DRB Application No.: <b>05DRB-00208 (SBP)</b>	Project # <b>1003764</b>
Project Name: <b>HOLIDAY PARK SUBDIVISION</b>	
Agent: <b>SMPC ARCHITECTS</b>	Phone No.: <b>255-8668</b>

TO: Sheran Matson, DRB Chair  
FROM: Stephanie Shumsky, Associate Planner  
SUBJECT: Project # 1003764

**DRB FINAL SIGN OFF FOR EPC APPROVED SRP**

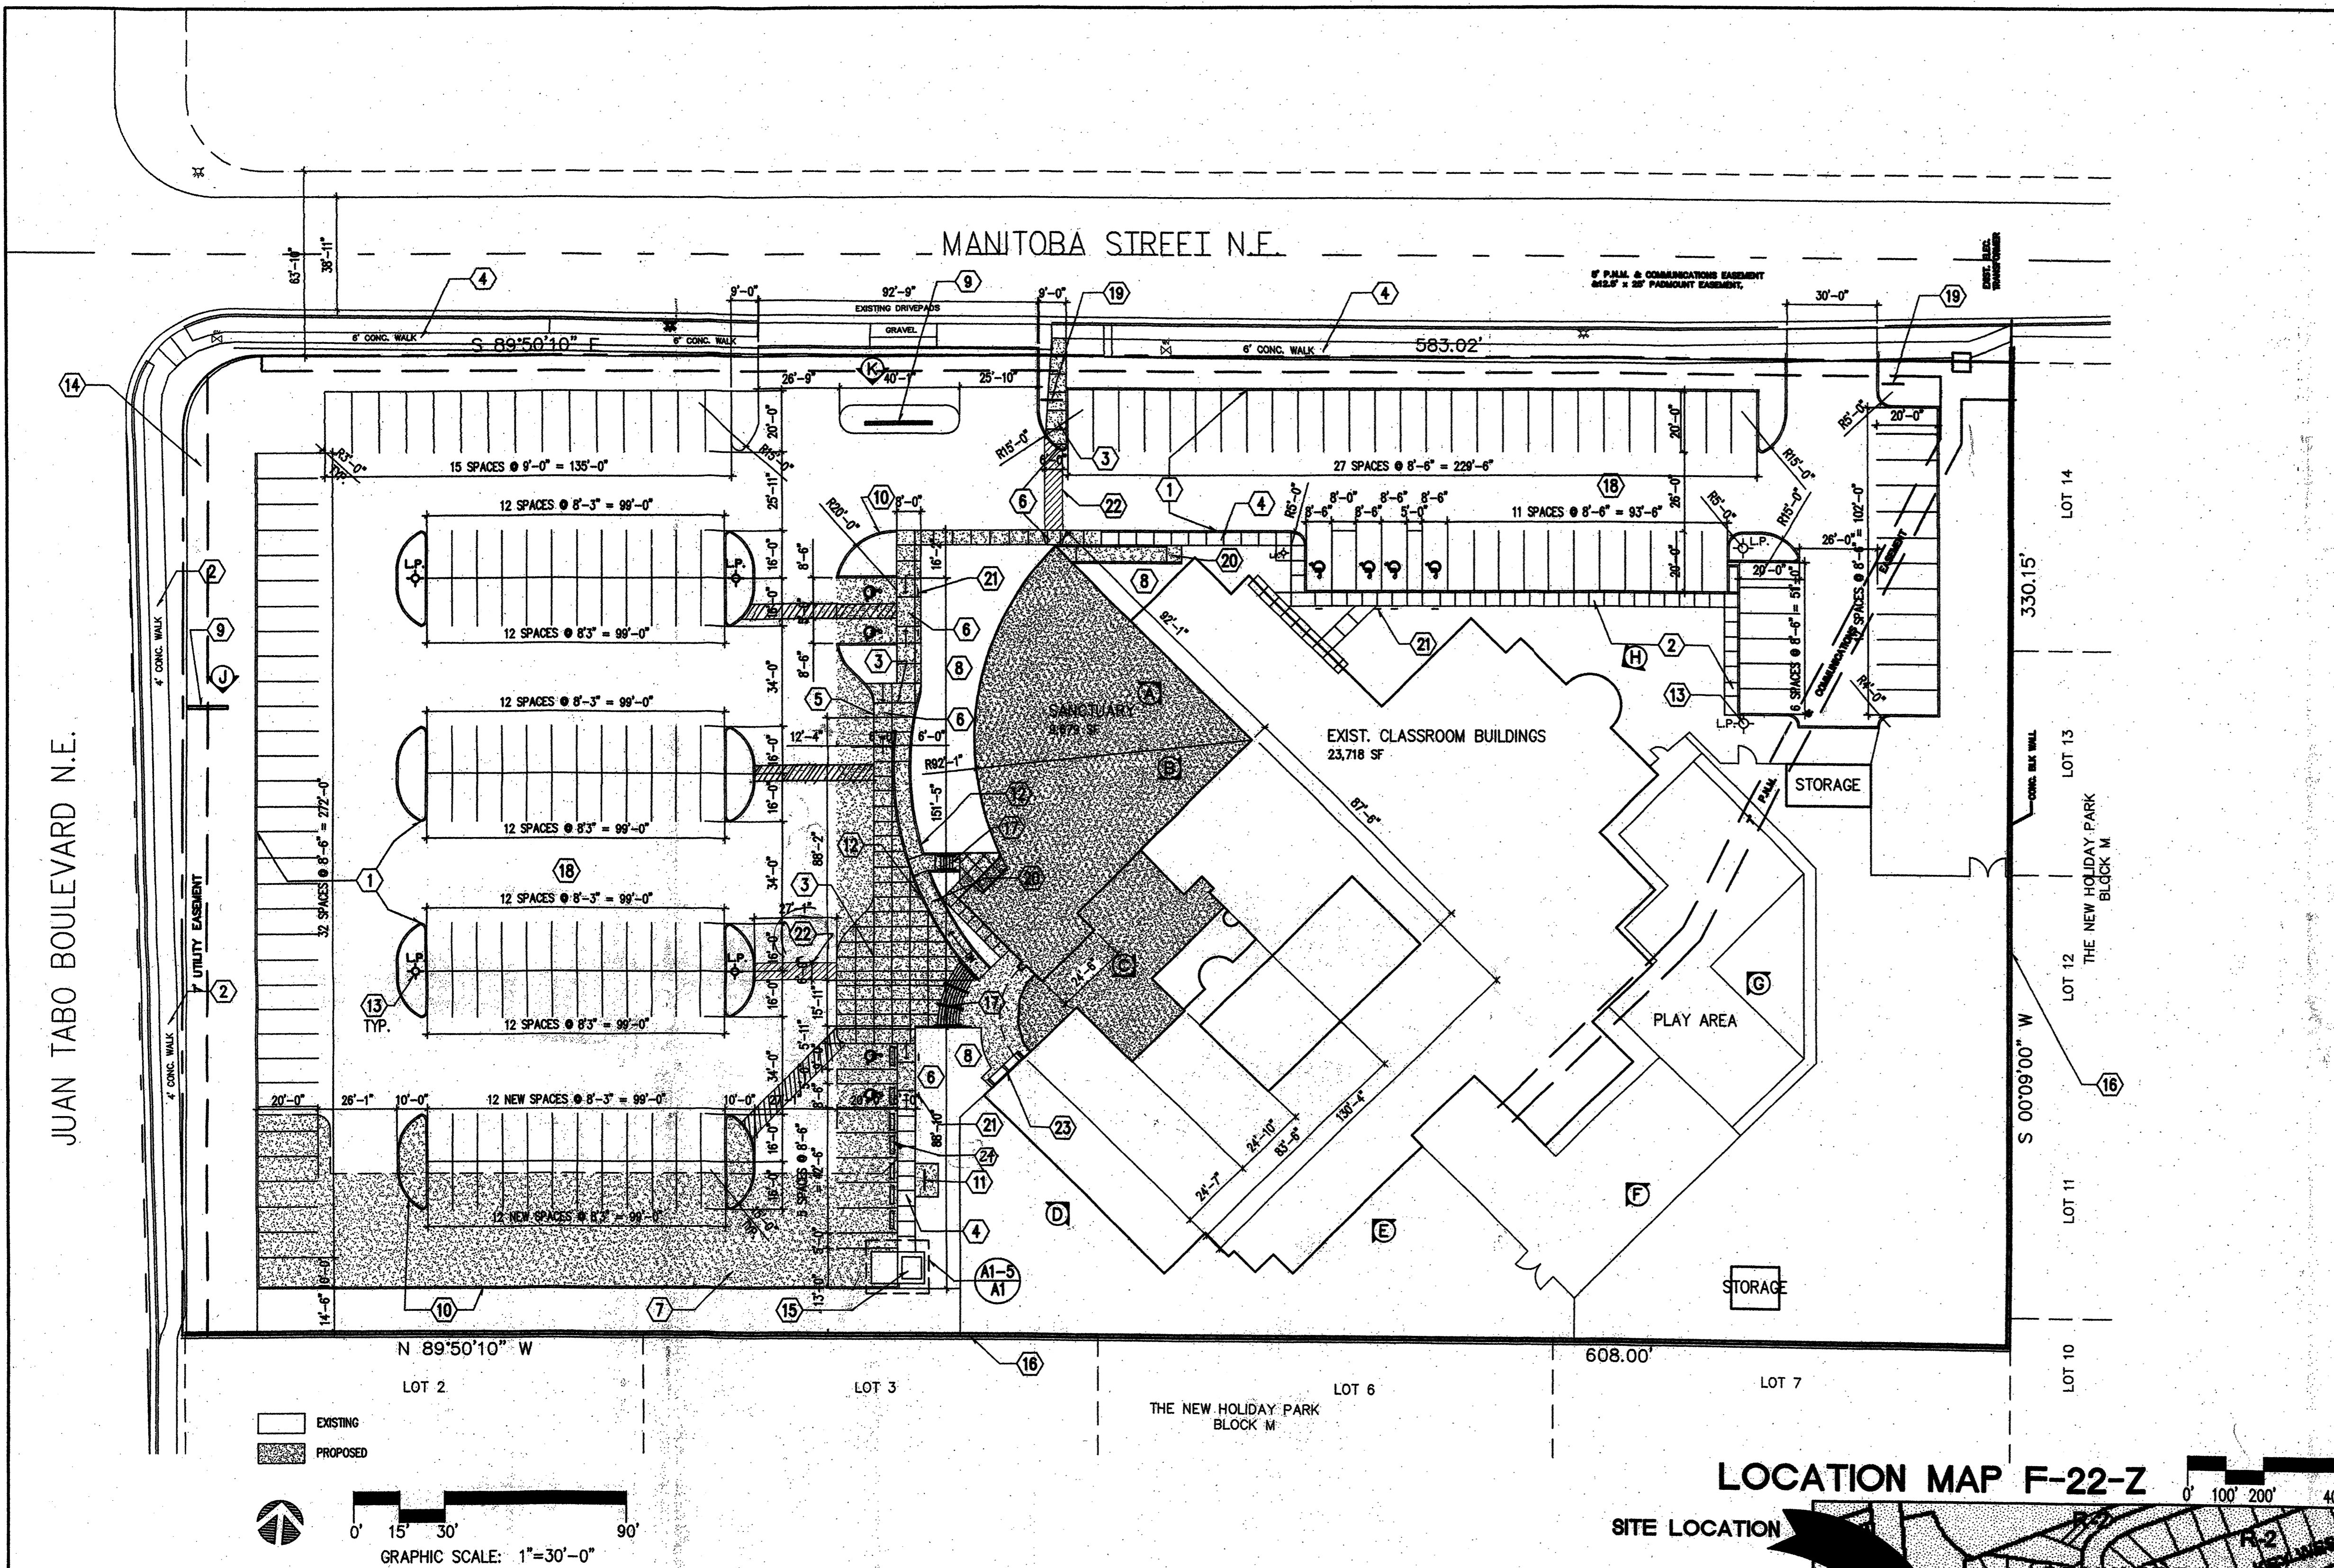
- Condition 2: Zoning Code Section 14-16-3-1(G6) has not been satisfied. This section states, "Parking subareas shall be linked to the main pedestrian walkway leading to the main entrance of the building by means of pedestrian walkways." Each parking island should be connected to the parking area abutting Juan Tabo Blvd. as well as connecting to the main pedestrian walkway leading to the main entrance of the building.
- Condition 5: The retaining wall's location has been identified on the Site Master Plan but not on the Grading Plan as indicated it shall be in condition 5. In addition, the retaining wall has not been dimensioned on the Grading Plan as stated it shall be in condition 5.
- The Site Development Plan/Site Master Plan does not reflect the applicant's changes to the number of parking spaces provided as indicated in his letter addressing the EPC's conditions.

**OVERALL SITE UTILITY PLAN**  
SCALE: 1" = 30'-0"

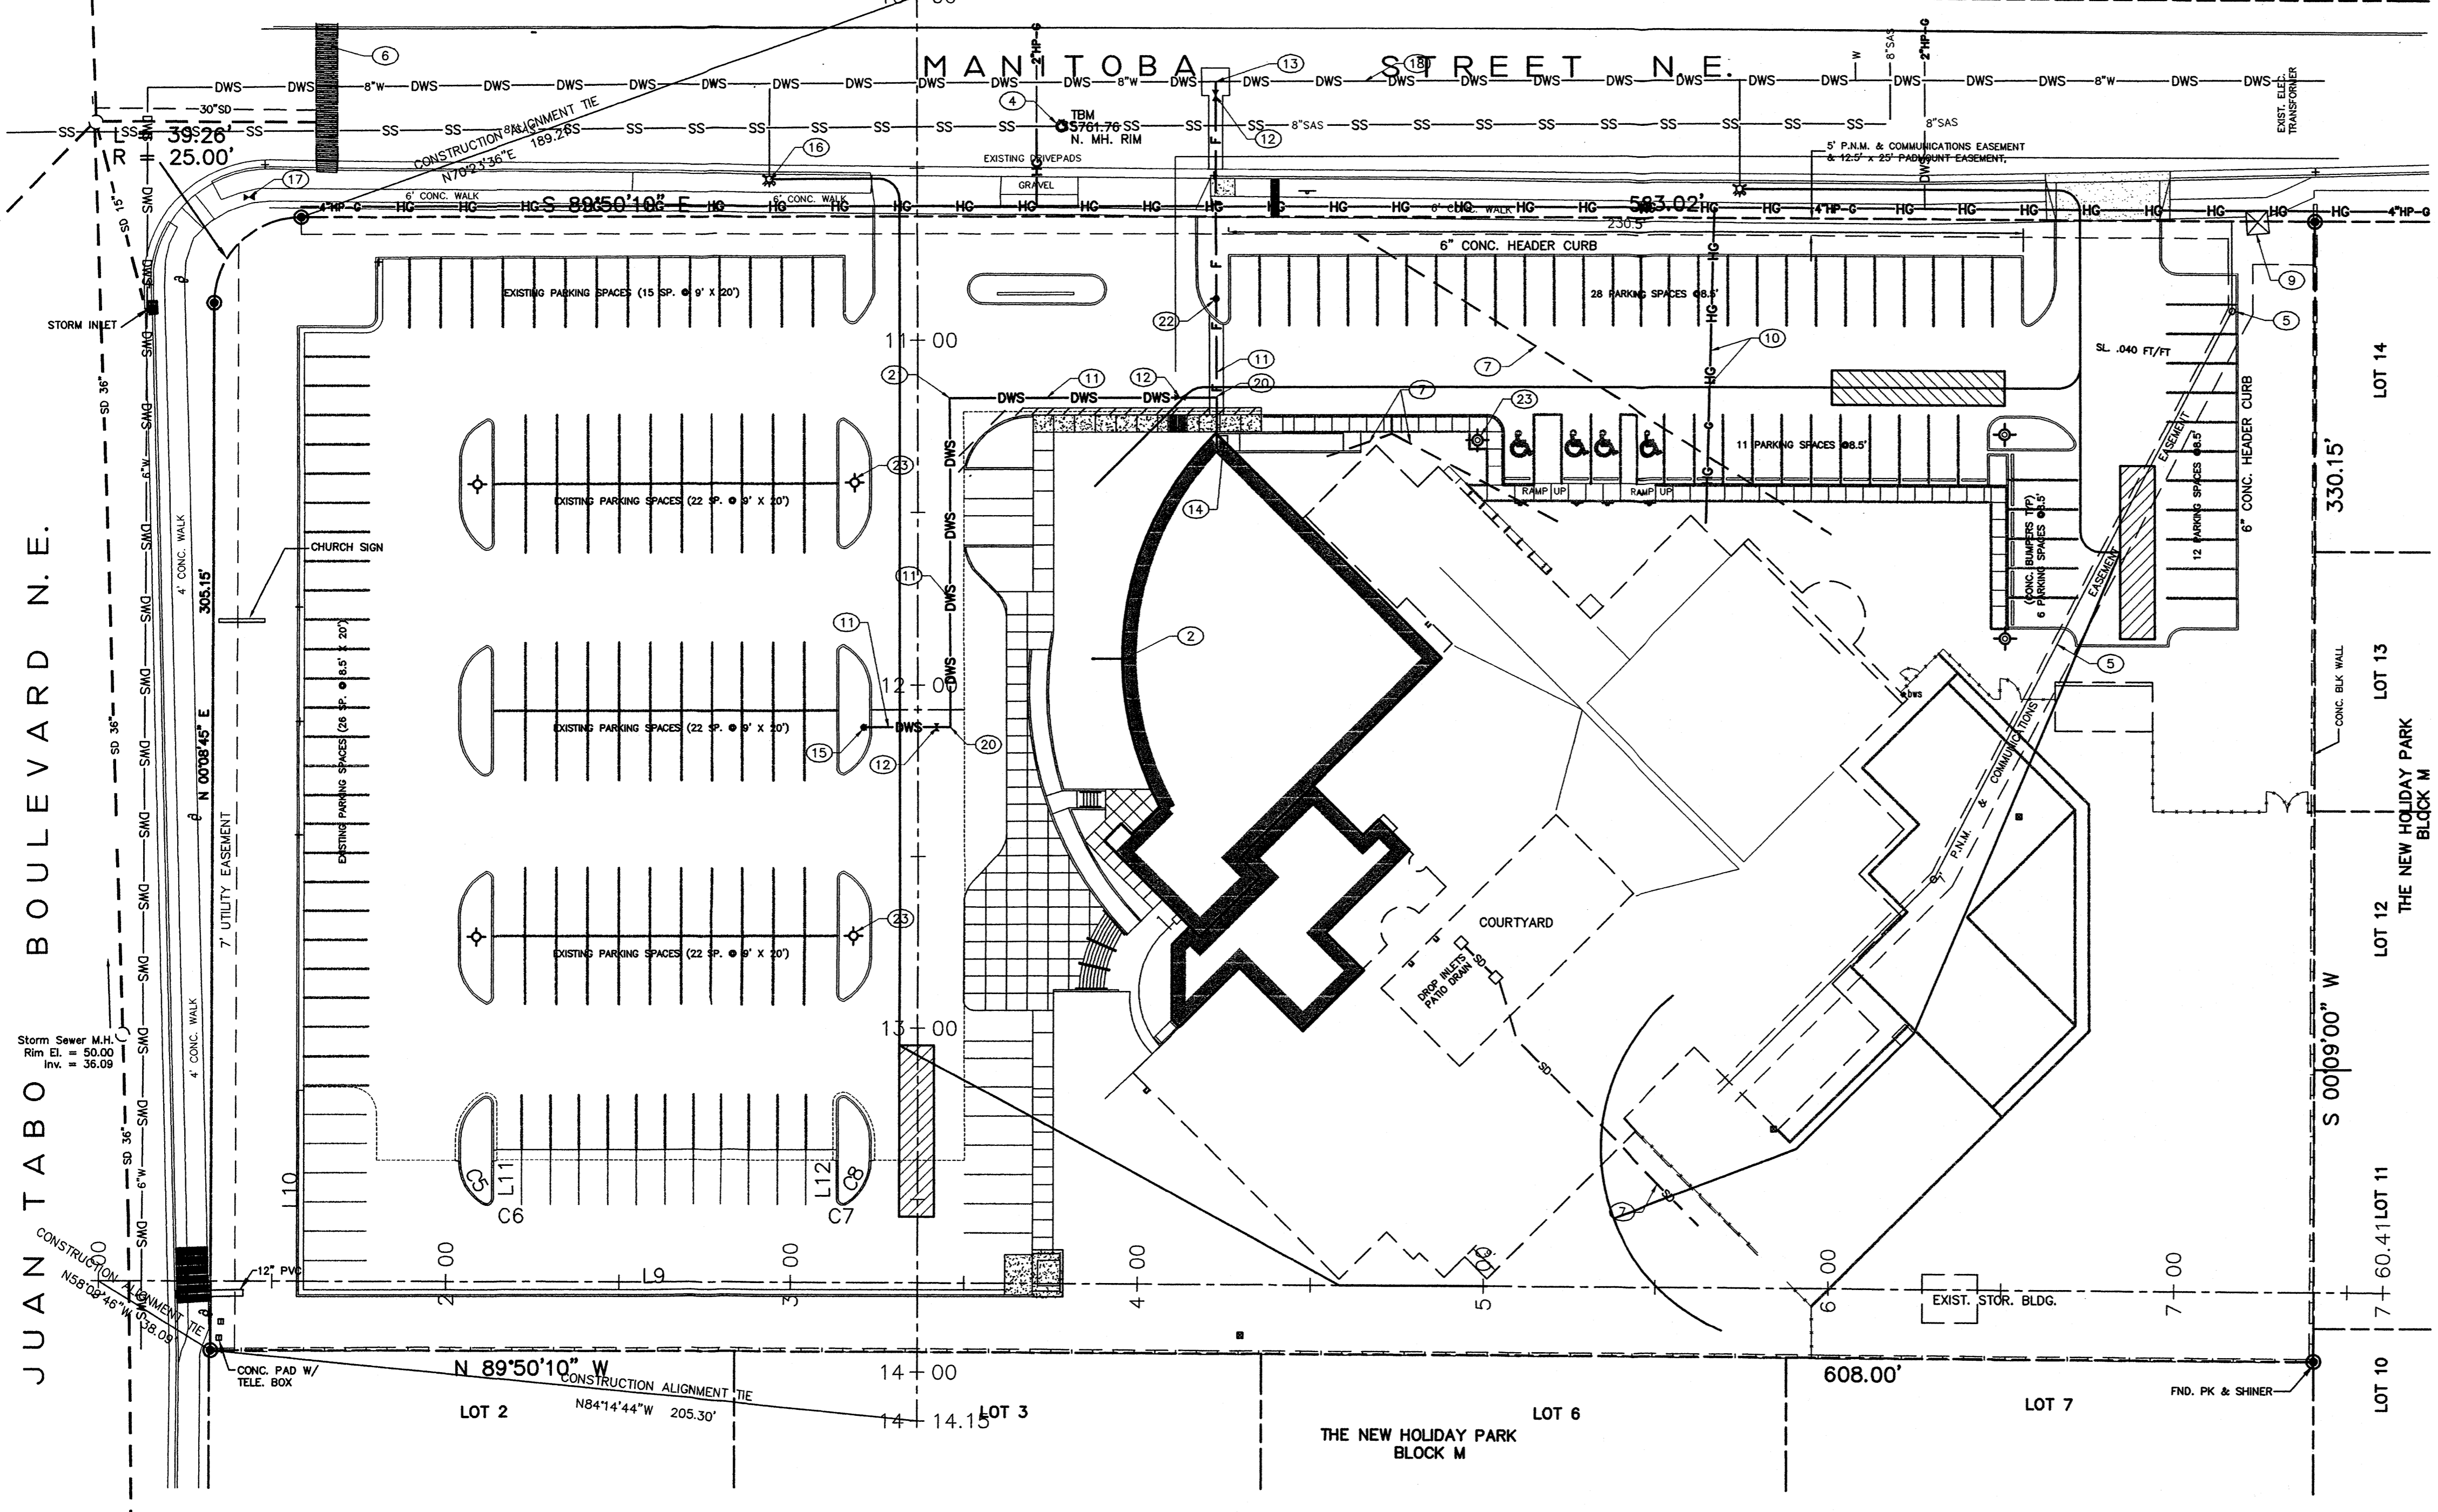
- TRANSPORTATION: 3- COPIES ! ORIGINAL  
 FORMING RUMORS / ok / 5-17-05  
 RECORD TEL /
- UTILITIES: Fire flow calculations
- CITY ENGINEER / AMAFCA:
- PARKS / CIP:
- PLANNING (Last to sign):
